KIRKLEES METROPOLITAN COUNCIL INVESTMENT & REGENERATION SERVICE

DELEGATED DECISION TO DETERMINE PLANNING APPLICATIONS

Reference No:	2023/62/91002/W
Site Address:	Corby, Birkby Road, Birkby, Huddersfield, HD2 2DR
Description:	Erection of two storey rear extension incorporating a roof terrace, single storey side and rear extensions incorporating a roof terrace, two storey feature entrance, garage/home office outbuilding and landscaping works including the formation of a tennis court with associated fencing and the creation of pedestrian access and alterations.
Recommending Officer:	William Simcock

Officer Report 2023/91002

scale	date	drawn	revision
SHOWN@A3	30.06.22	RL	
drawing no.	RG324 / PL06		D

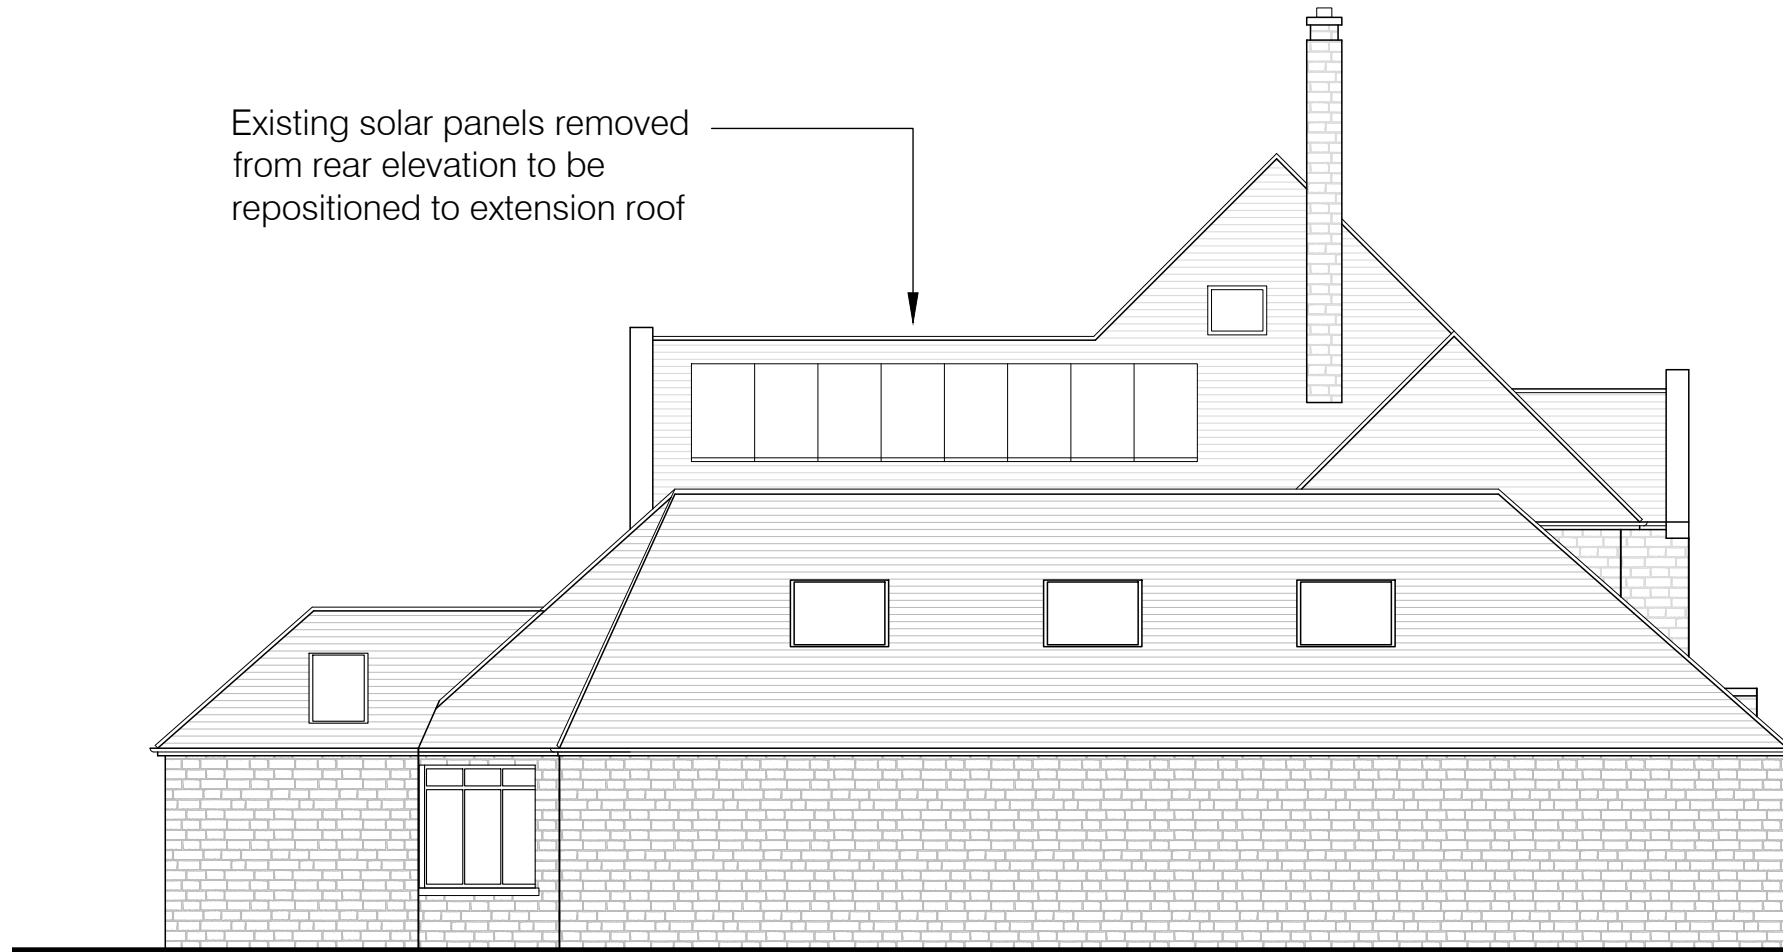
It is considered that as originally submitted it would have looked too imposing; changes made since then (the addition of downpipes, additional windows, and the lowering of the stone parapet at balcony level) although small in scale, are considered to have significantly improved its appearance. With these amendments, and as it would be seen in the context of a building with a high roof, and with a large separation distance between the building and its rear and side boundaries, it is considered that it would not seem overly massive or imposing and would not dominate the existing building, and that the design details, including roof style, would be appropriate to the context.

7. Before the development is first brought into use, the existing solar panels shall be re-sited as shown on plan RG324 / PL06 and made operational, and thereafter retained as such.

scale SHOWN@A3	date 29.09.23	drawn RL	revision B
drawing no. RG324 / BR01

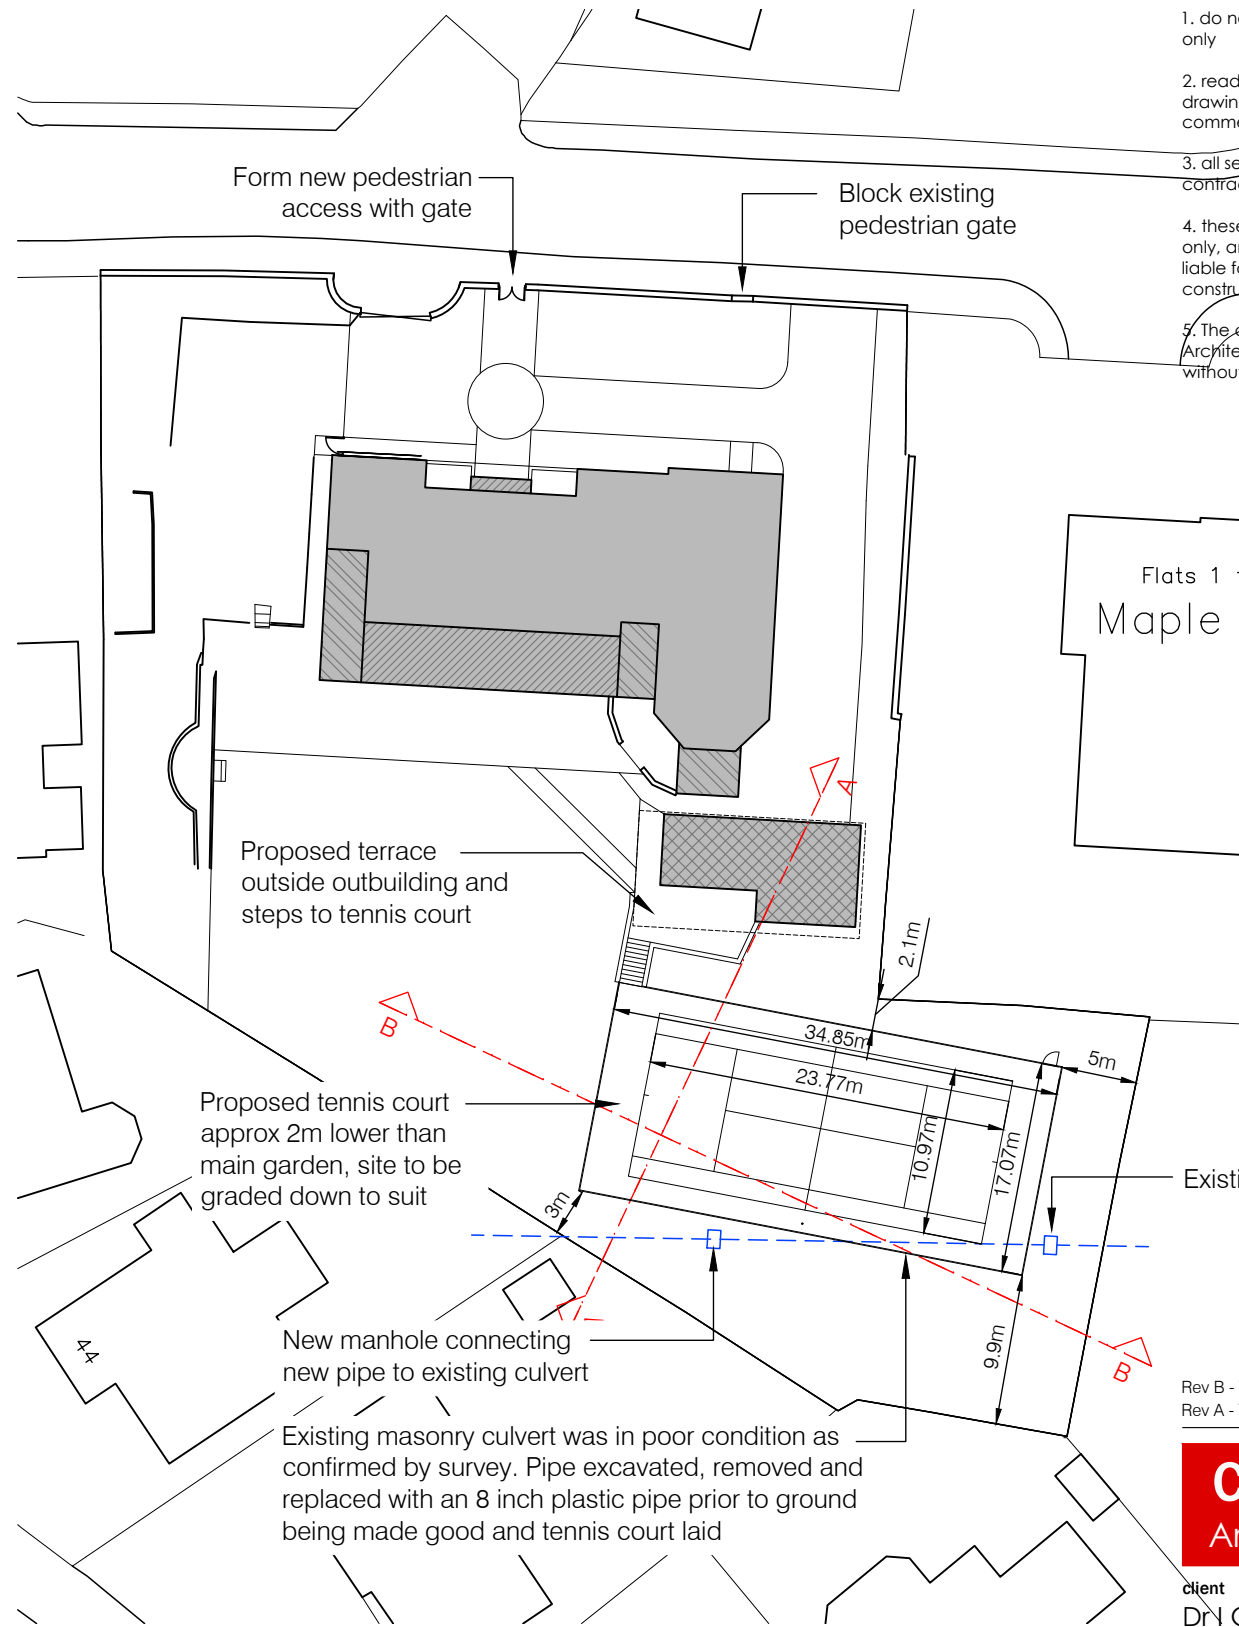
The proposed tennis court is not a building or extension and is therefore not covered by the guidance in the SPD. It has been modified during the course of the application – the stepped terrace that was to have formed part of the proposal has been deleted and the land will be graded down to make up the difference in levels. It is considered that the excavation and levelling works would not have a detrimental effect on local character. The proposed fencing, at 2.75m, is higher than would normally occur in a domestic setting, but is considered reasonable given the intended use, so as to minimise the risk of balls being lost and having to be retrieved and being of lightweight design and located near the bottom of a slope, it is considered it would not be excessively prominent or appear inappropriate to its setting.

A culverted watercourse crosses the site. The Lead Local Flood Authority initially expressed concerns about how this would be affected by the excavations to form the tennis court but have now confirmed that the improvements shown on plan RG 304 BR1 (including a new manhole and the installation of a plastic pipe to replace a section of the concrete culvert) are acceptable. It is recommended that these be conditioned in the interests of controlling possible future flood risk and that the development would thereby accord with the aims of policy LP27 of the KLP.

8. The measures to repair the culvert and facilitate its future maintenance as shown on plan RG 304 / BR01 shall be implemented before the works to form the tennis court are substantially complete and shall thereafter be retained as such.
